Objections submitted in response to East Pye Solar

PINS Reference: EN0110014

Site 1 - Great Moulton:

Assessing the Full Extent of the 1A–1D Development Footprint

- 9) The ZTV analysis only considers the BESS and 400kV substation within the BESS Site.

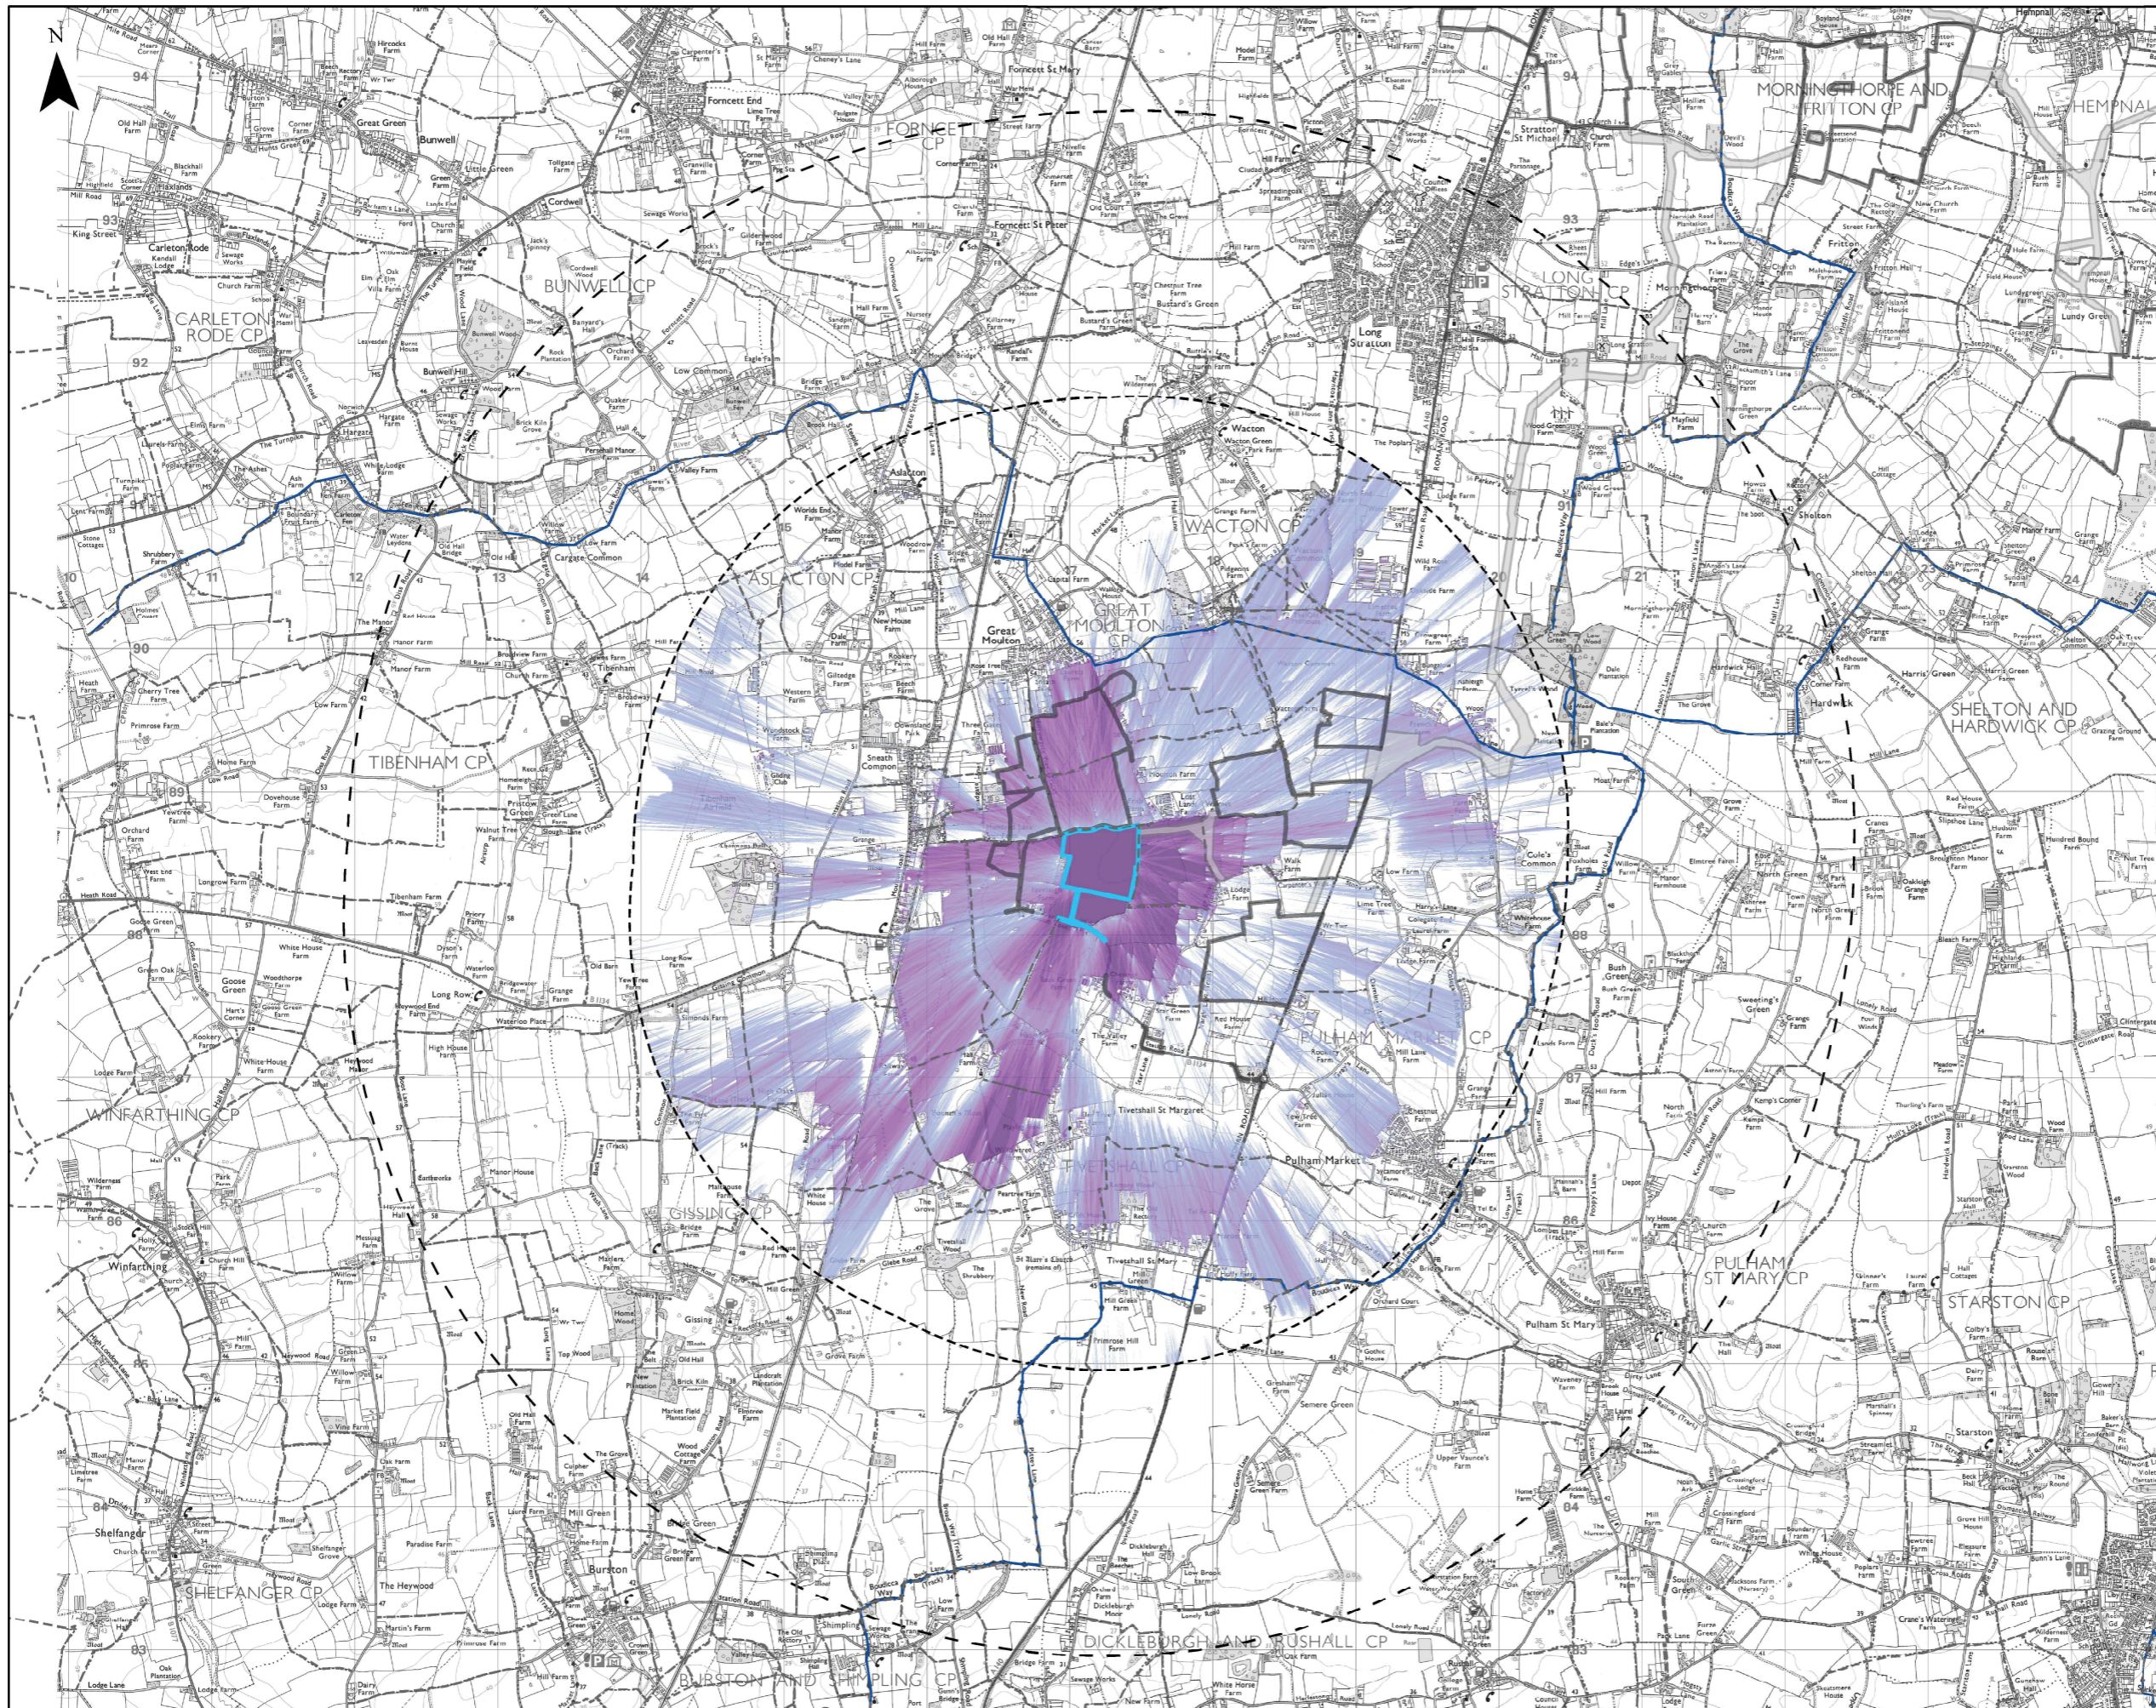
The Structure of East Pye's documents and lack of clarity, means that we are unable to obtain a full understanding of the design being proposed. From incorrectly labelled images and photographic co-ordinates making it impossible to actually ascertain what and where they have photographed - see document EN01110014, this document actually includes the National Grid Substation although labelled BESS.
